Recommendation Report for Approval of Reserved Matters Following Outline Approval

REF NO: BN/26/15/RES

LOCATION: Land North of Yapton Road and
East of Garden Crescent
Barnham

PROPOSAL: Approval of reserved matters following outline consent BN/7/12/ for 44 No. dwellings including 30% affordable, comprising of a mix of 2 & 4 bed houses with associated landscaping & works.

Soft Landscape Layout - Residential Planting Proposals

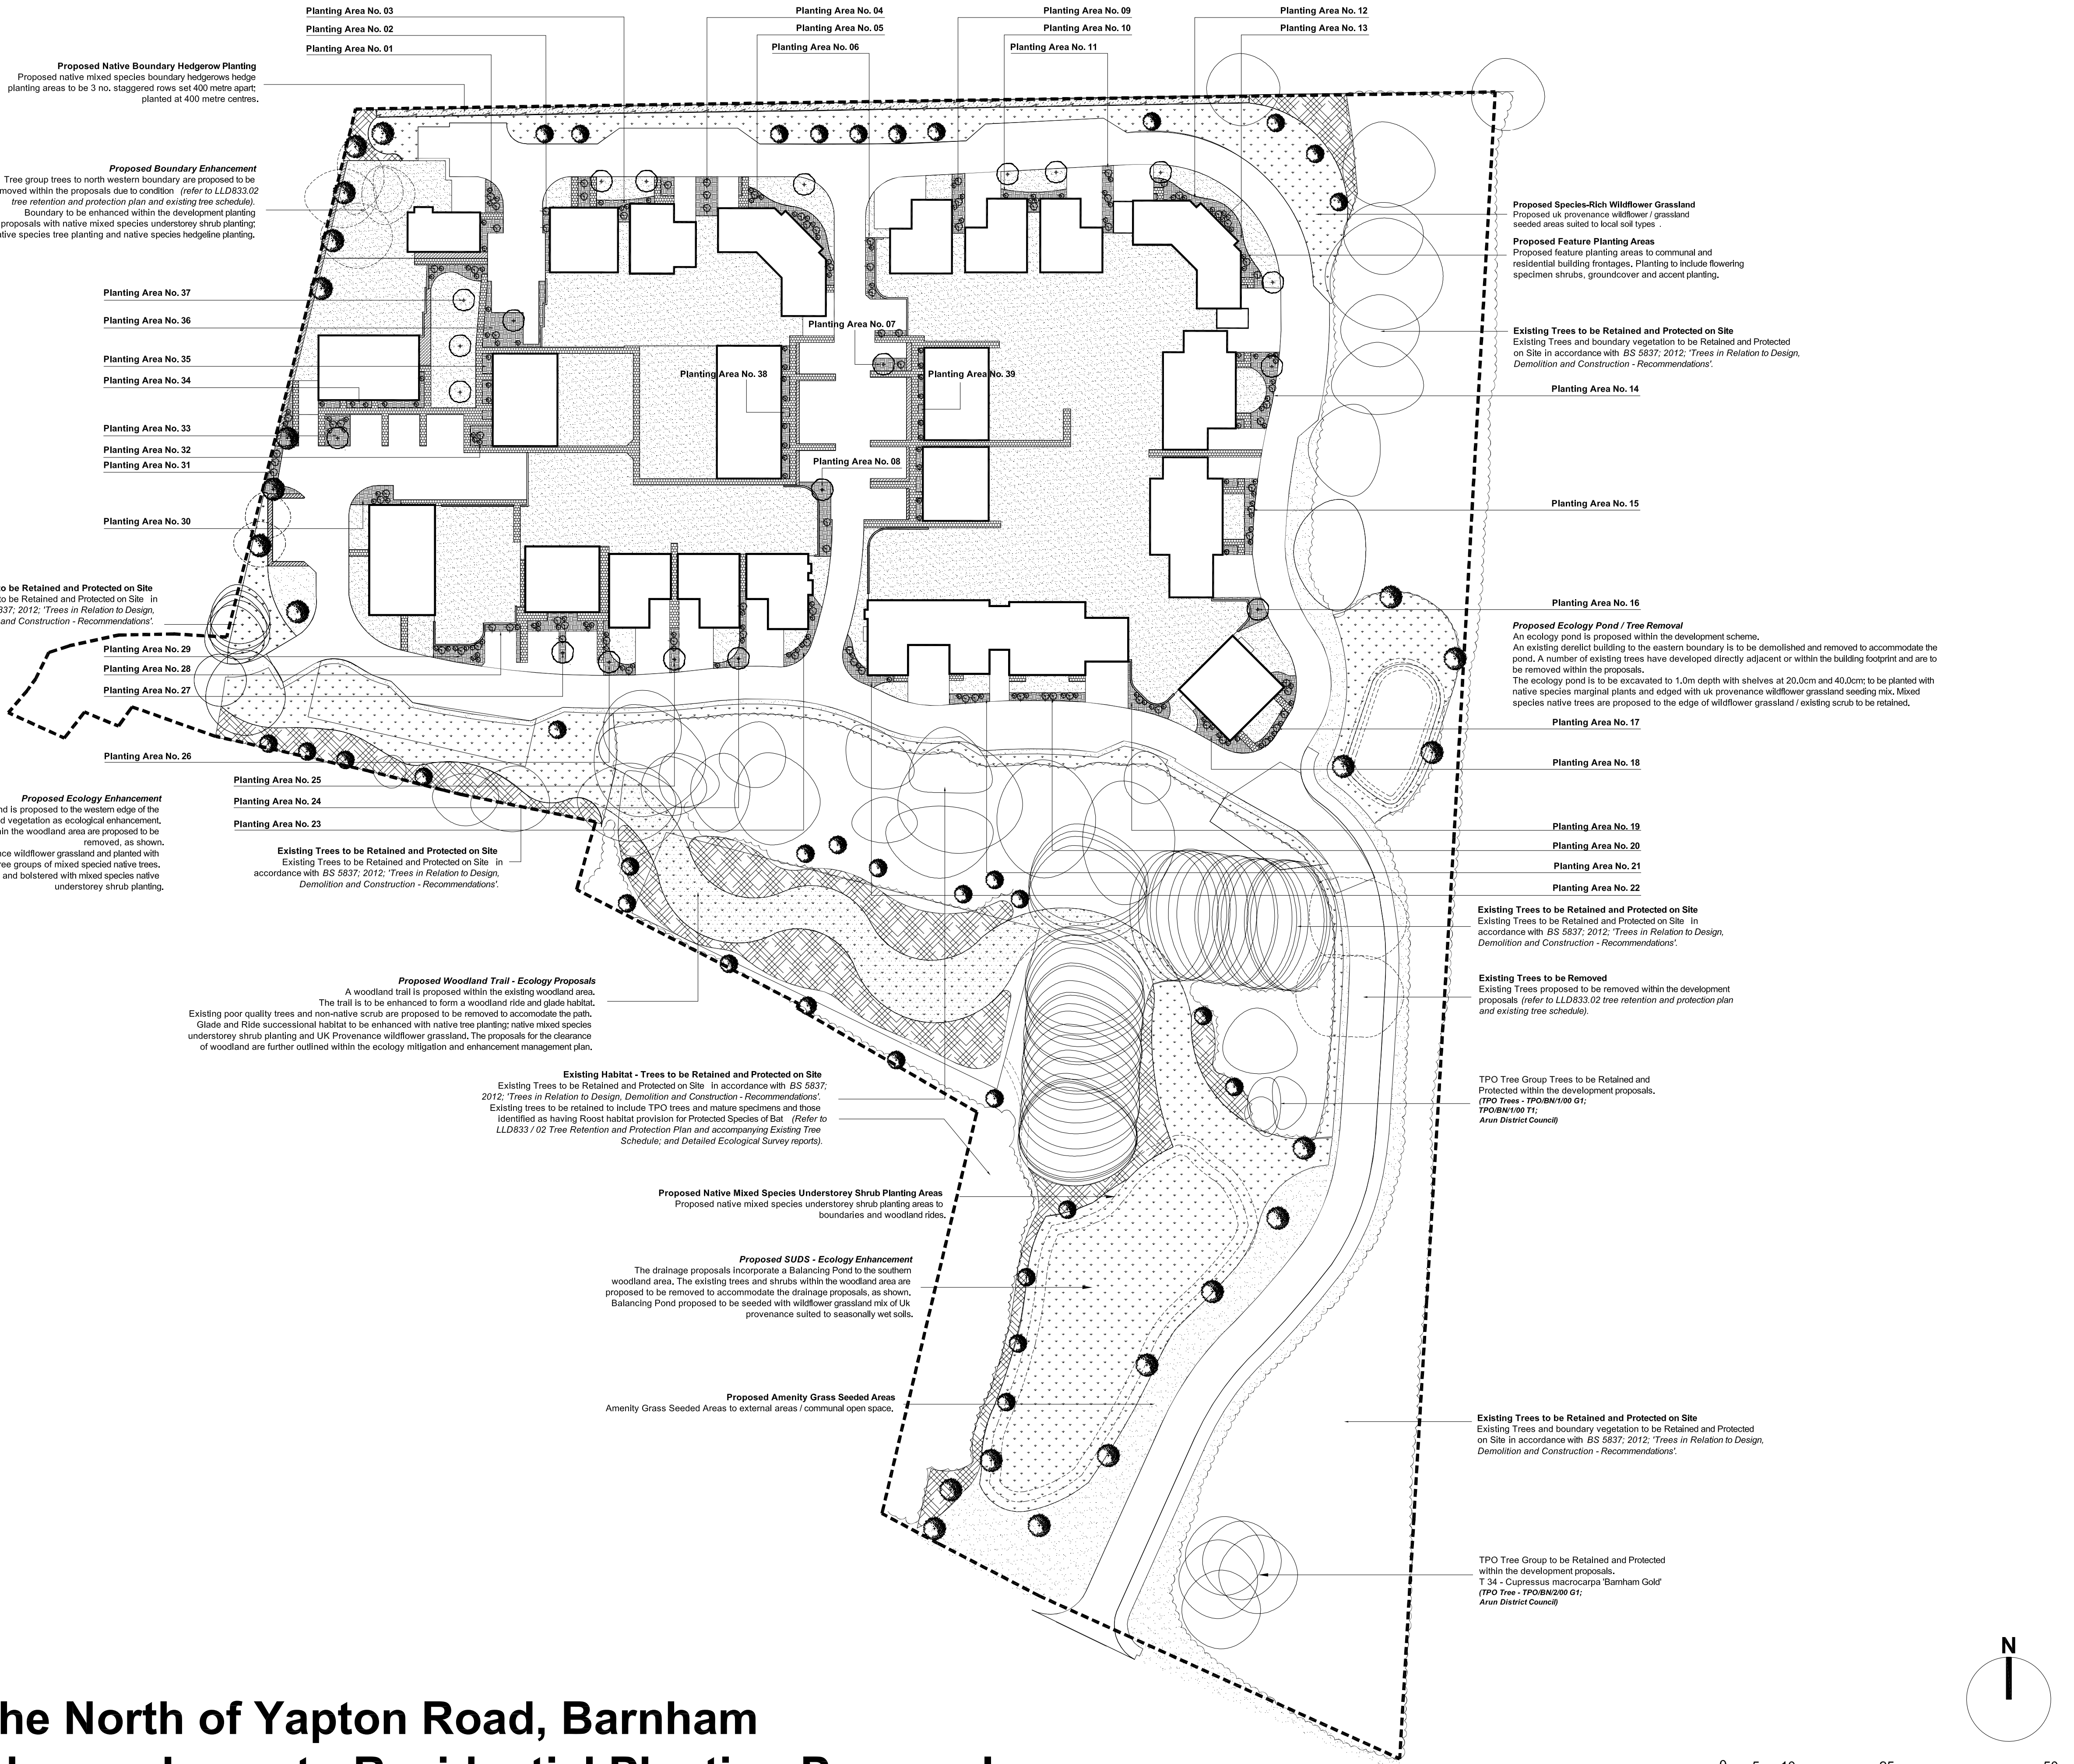
WSCC Highways comment that landscaping adjacent to the carriageway particularly at junctions and on the bend on the access road should be set back a minimum of 2m from the edge of the carriageway would mean that within the development and on the approaches landscaping would not be provided in areas where it is most desirable in terms of integration with the layout and softening the appearance/providing a good standard of amenity to resident. Such an 'engineered' approach would not be desirable nor in the best interests of achieving a high quality of scheme. It is not considered that a 2m setback should be pursued therefore.
